**KIRKLEES METROPOLITAN COUNCIL  
INVESTMENT & REGENERATION SERVICE**

**DELEGATED DECISION TO DETERMINE PLANNING APPLICATIONS**

Reference No:	<b>2023/62/91939/W</b>
Site Address:	11, Burniston Drive, Oakes, Huddersfield, HD3 3PR
Description:	Erection of single storey rear extension
Recommending Officer:	Lucy Taylor

## **Officer Report.**

Drg No:  
BD05.C

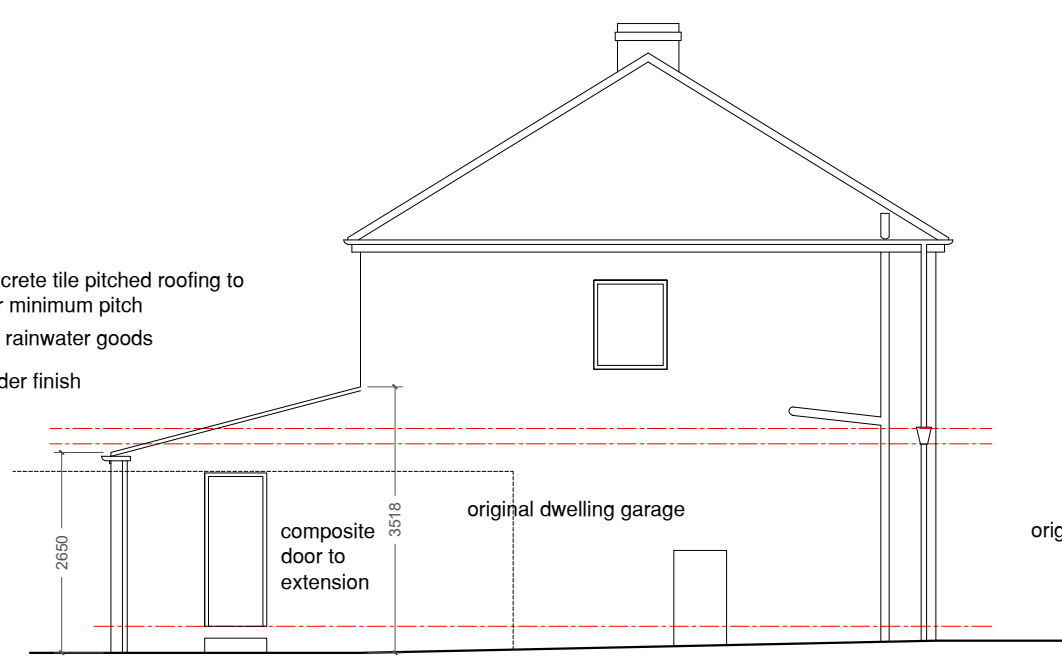
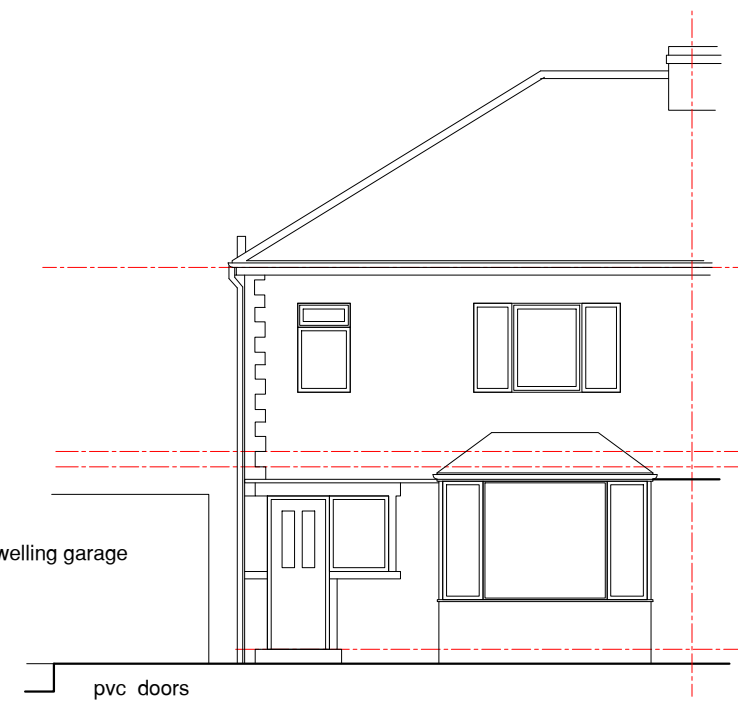
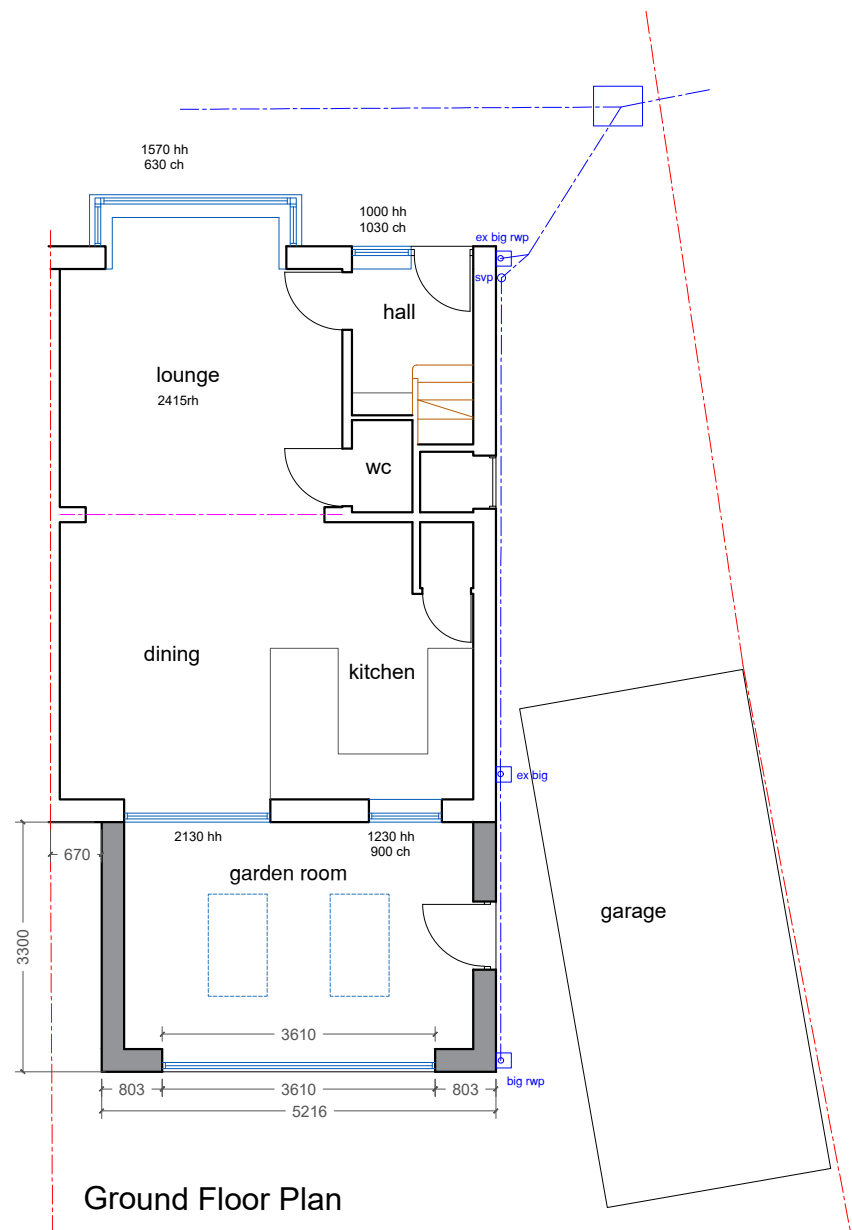
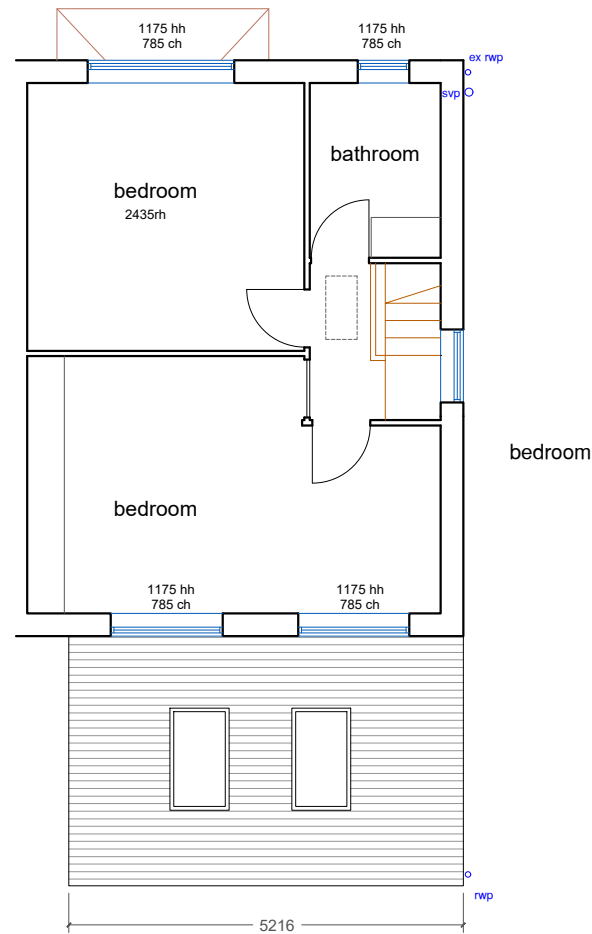
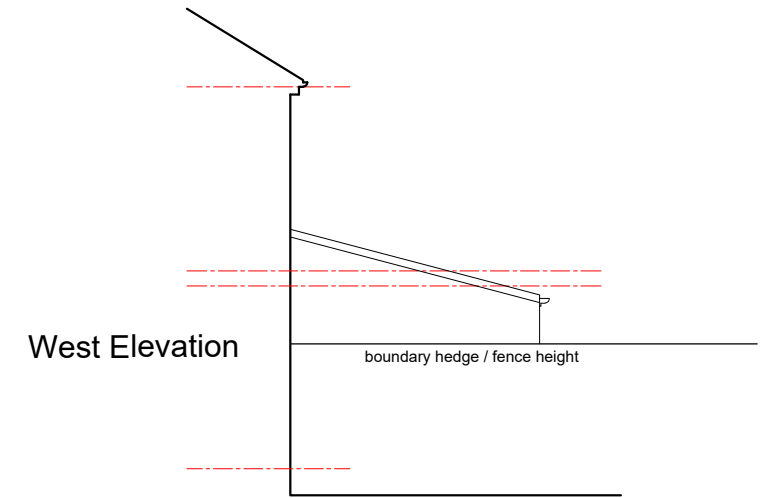
Officers note that the extension would exceed the limitations of the aforementioned SPD with regard to projection, projecting 0.3 metres beyond the recommended 3 metres for semi-detached properties, and also acknowledge that the extension would retain a separation distance of 0.67 metres rather than the recommended 1 metre. However, in the instance of this application, these marginal infringements are concluded acceptable on the individual merits of the site. These individual merits been that 11 Burniston Drive benefits from full Permitted Development Rights and the Permitted Development fallback of building a 3-metre rear extension along the boundary is considered more detrimental to residential amenity than the extension as proposed under this planning application, discussed further in the next section of this report.

The proposed extension to 11 Burniston Drive would fail to be entirely compliant with the design requirements of single storey rear extensions as set out in the Council's House Extensions and Alterations SPD, set away from the shared boundary with No. 13 by only 0.67 metres rather than by the recommended 1 metre. In addition, the proposed single storey rear extension would not be entirely compliant with the 45-degree rule as set out within Key Design Principle 5 of the SPD.

No glazing is proposed in the side elevation facing this neighbouring property, resulting in no detrimental impacts to residential privacy as a result of overlooking.

Notwithstanding this, these marginal infringements to guidance are considered to be an improvement upon the potential fallback position which could be attained at 11 Burniston Drive, whereby the property still benefits from Permitted Development Rights and could therefore build a 3-metre rear extension up to the shared boundary. This fallback position would be considered to pose greater harm to the residential amenities of No. 13 with regard to overbearing and/or overshadowing. Therefore, in this instance, the individual merits of the applicant site are considered to warrant the grant of approval with regard to residential amenity and impacts to No. 13 Burniston Drive.
